Mountain View Electric Association, Inc. (MVEA) has these comments about the following:

Project Name: Palmer Divide, Filing #1A

Project Number: VR-17-002

Description: Approval is being requested for the replat of Palmer Divide, Lots 16 & 17 to reconfigure the common lot line, forming two-5 acre lots. These lots are located at 6365 & 6425 Connaught Drive in Section 31, Township 11 South, Range 65 West.

# PALMER DIVIDE FILING NO. 1A

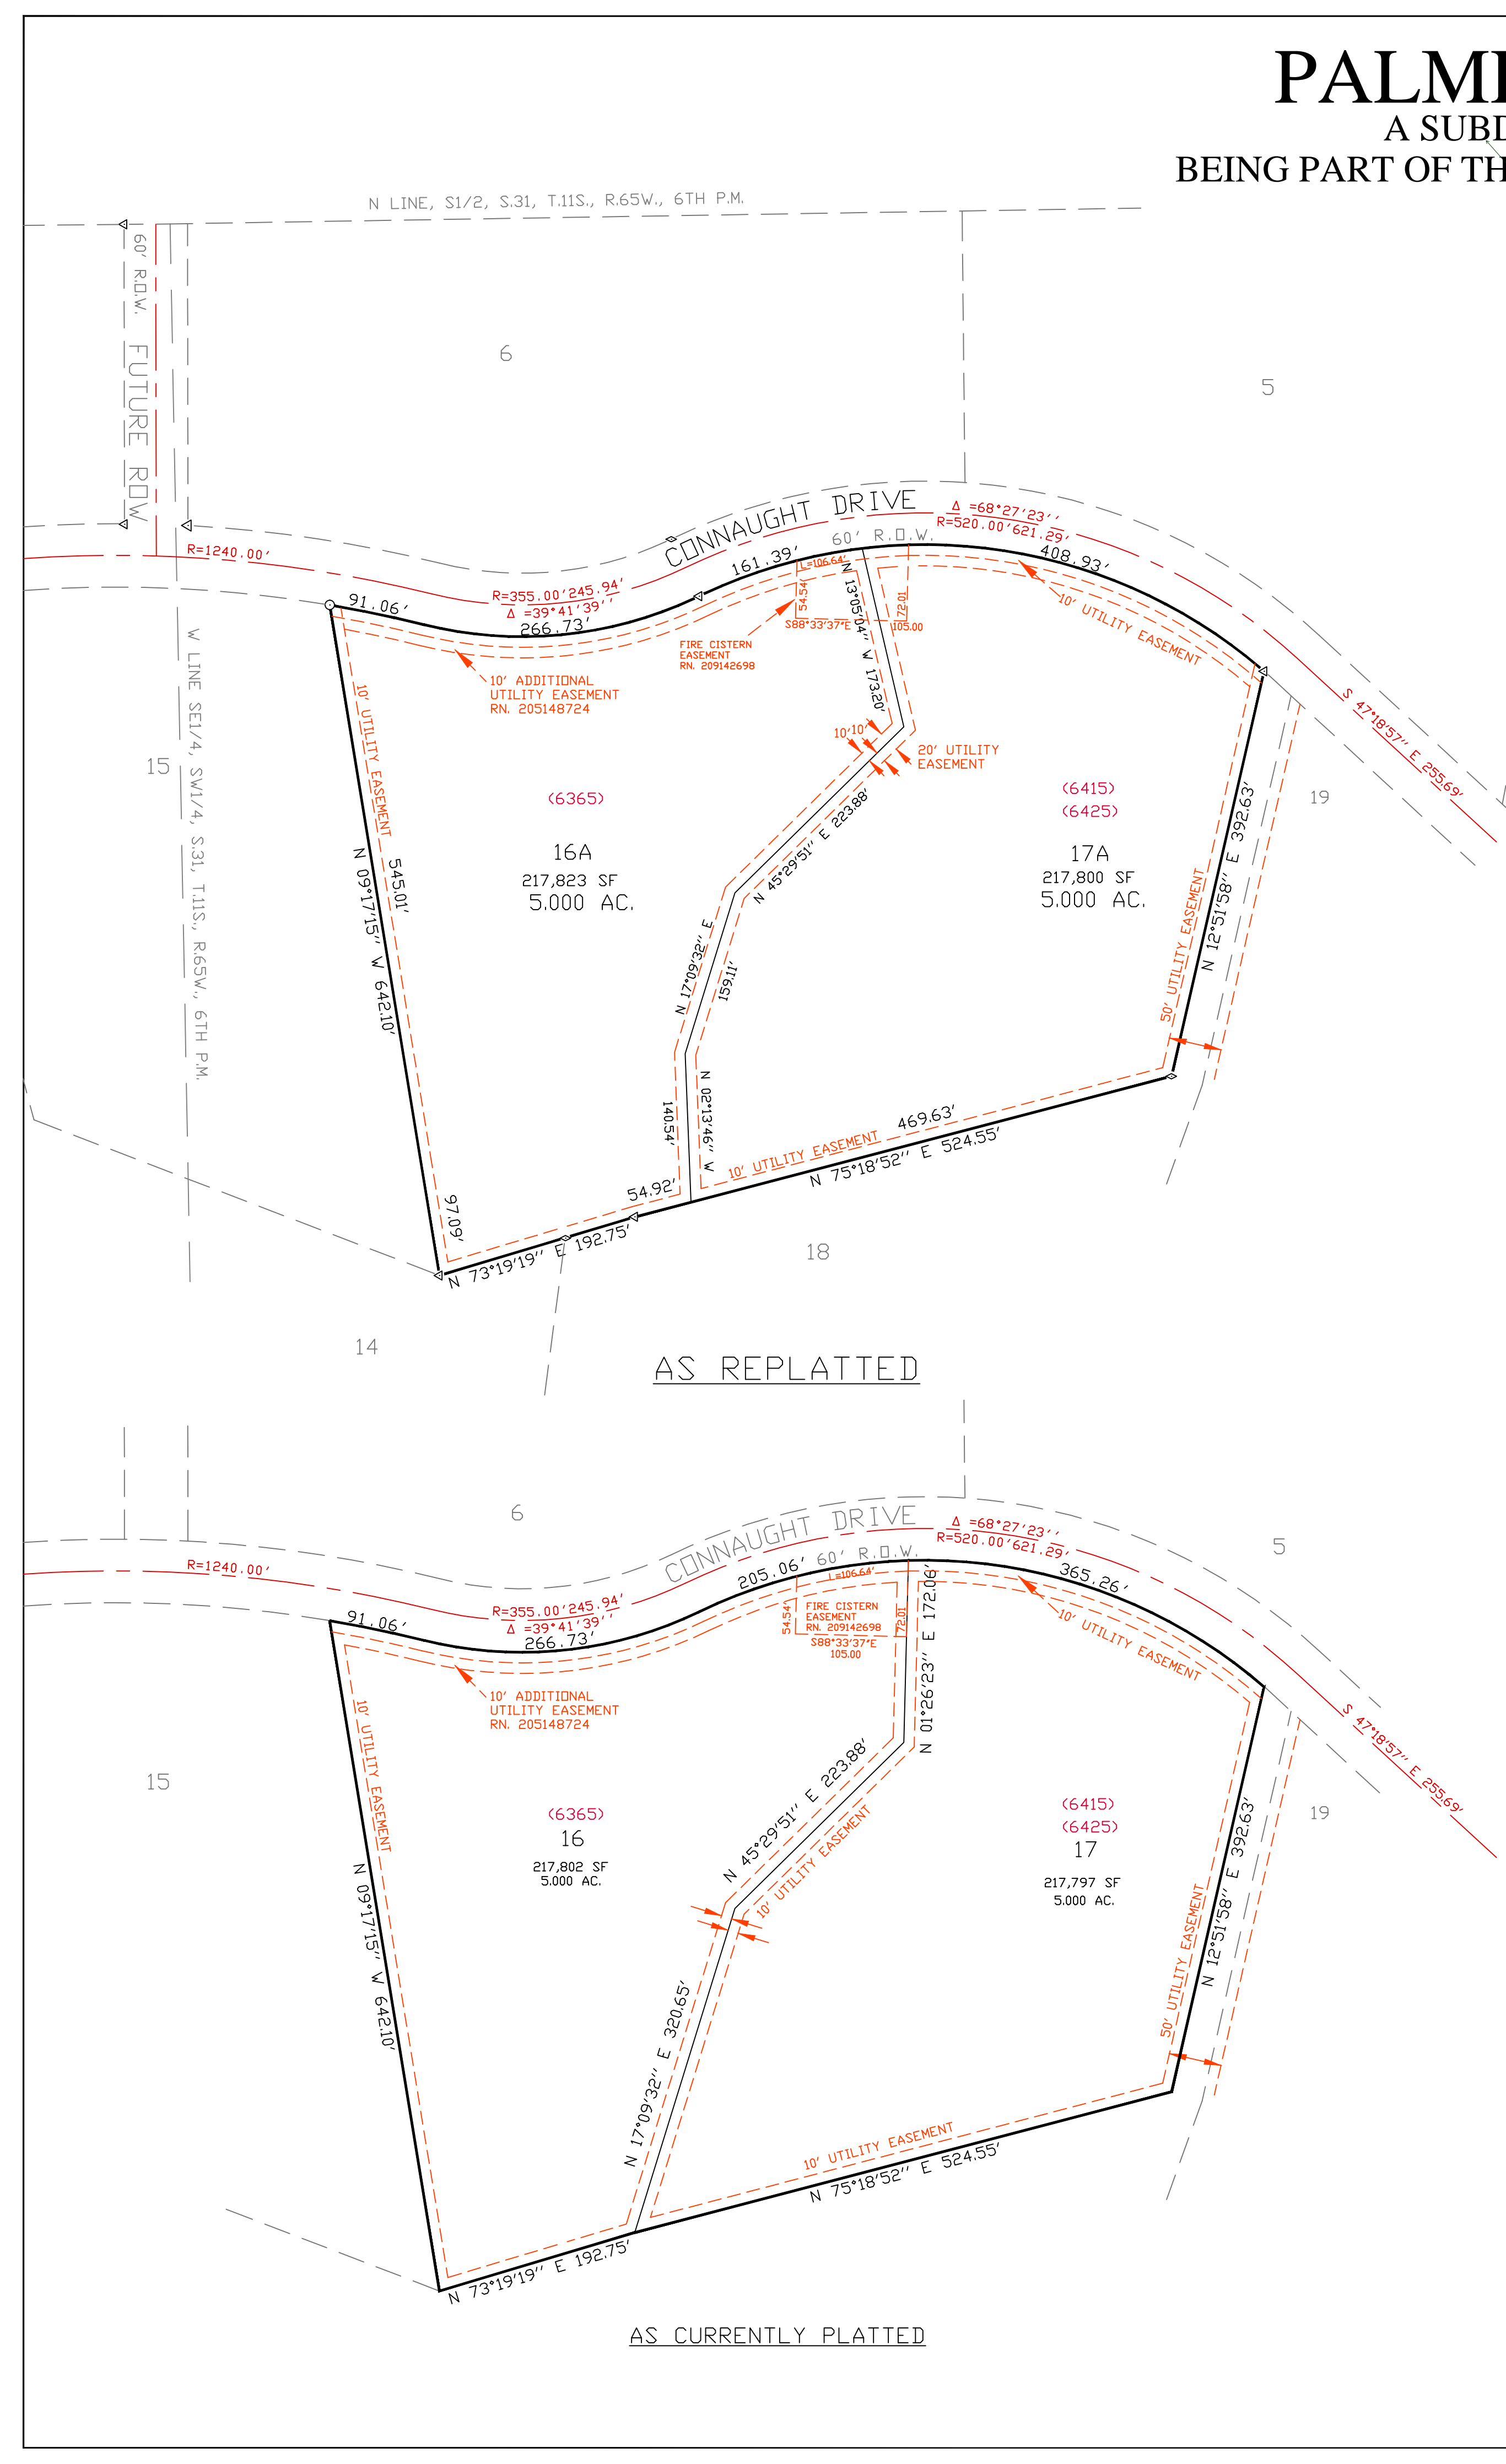
MVEA has no objection to the common lot line adjustment between these two residential lots with the understanding that MVEA has existing facilities near and within these parcels of land. If there is any removal or relocation of facilities it will be at the expense of the applicant. MVEA also requests platting of existing MVEA facilities with easement on the plat.
